November 20, 2015

SUBJECT: Permit Modification Request for Section 404 Individual Permit and Section 401 Individual Water Quality Certification for the US-74 Monroe Connector/Bypass in Union and Mecklenburg Counties. STIP R-3329 and STIP R-2559, Division 10, Debit WBS Element 34533.1.TA1 in the amount of \$570.

Reference: US Army Corps of Engineers (USACE) 404 Permit issued May 8, 2015; Action ID: SAW-2009-00876
NC Division of Water Resources (NCDWR) 401 Water Quality Certification Permit issued March 6, 2015; NCDWR Project No. 02-0672 V3

PERMIT DRAWINGS
SHEET 183 OF 267
REVISED: 11/16 /2015

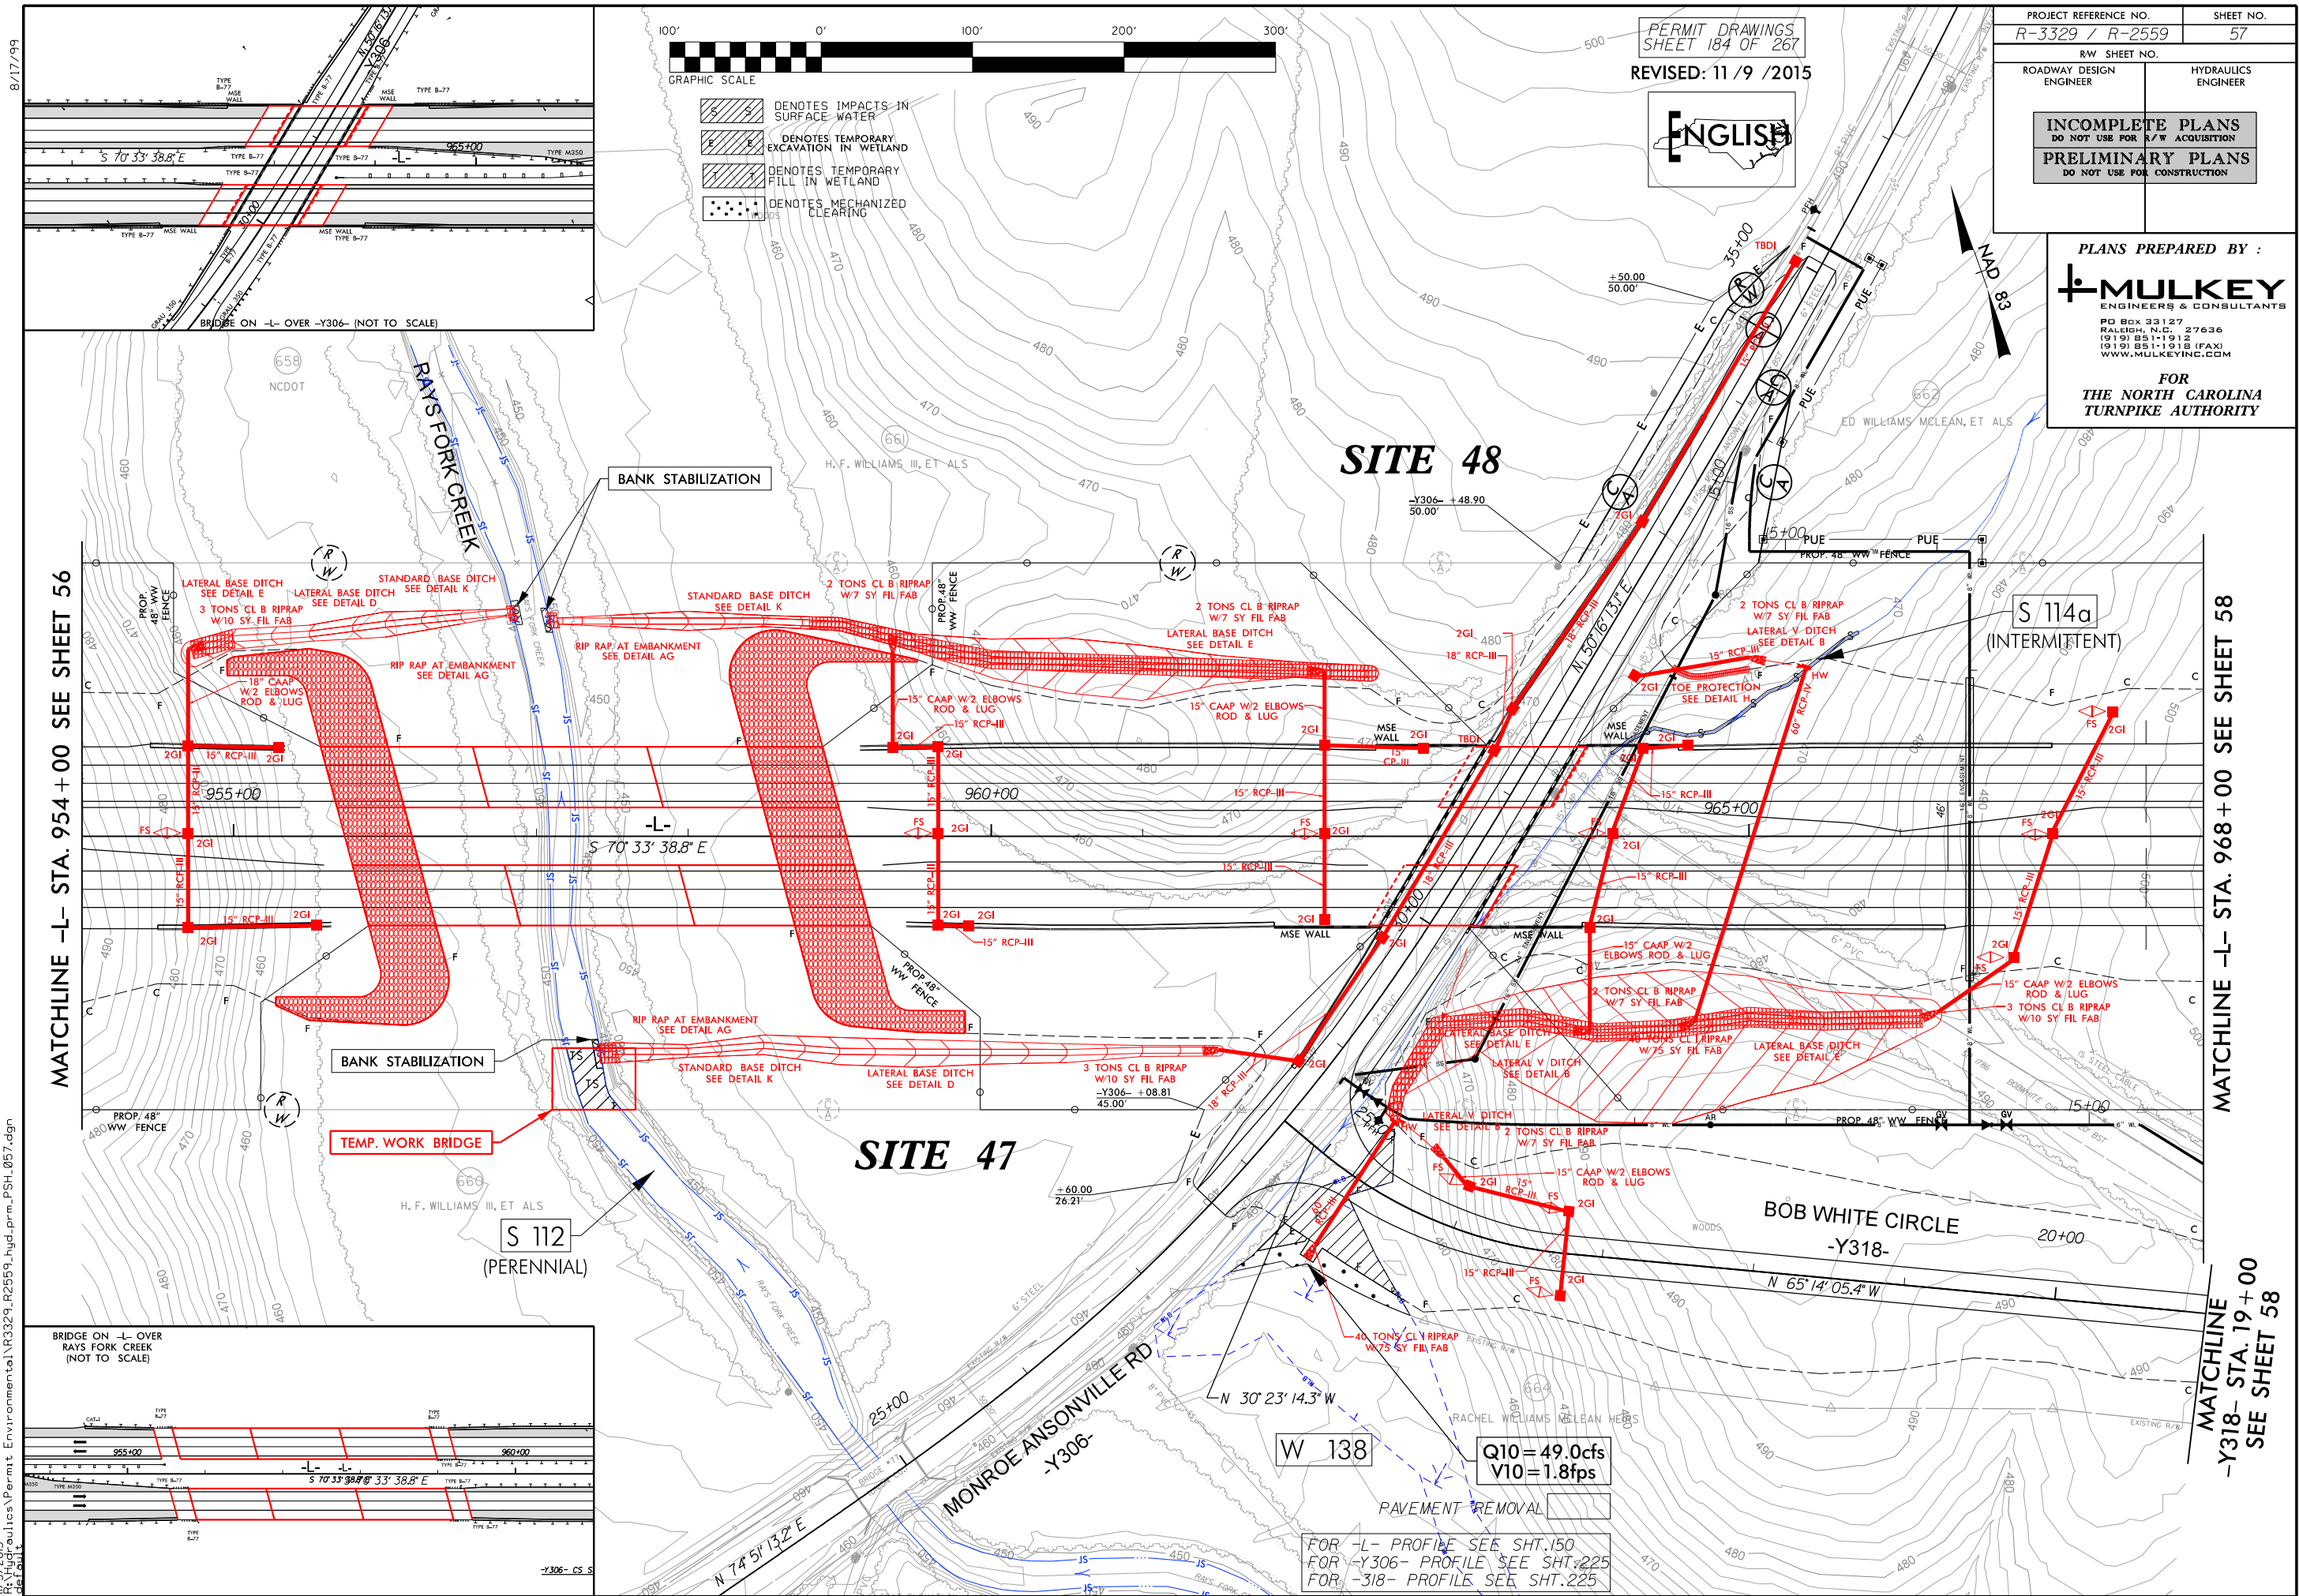
Permit Site 48 (Revised Permit Drawings 183 and 184 of 267):

During the relocation of the sanitary sewer utility, two minor impact revisions are required:

1. The fill slope had to be slightly altered, as such what was initially going to be 0.01 acre of temporary fill became permanent fill, increasing that total from 0.06 to 0.07 acre.
2. There will be 0.01 acre of temporary excavation in wetlands to install the utility line. The area will be revegetated with native vegetation upon completion.

This impact is shown in the blow up on revised permit drawing 183 of 267.
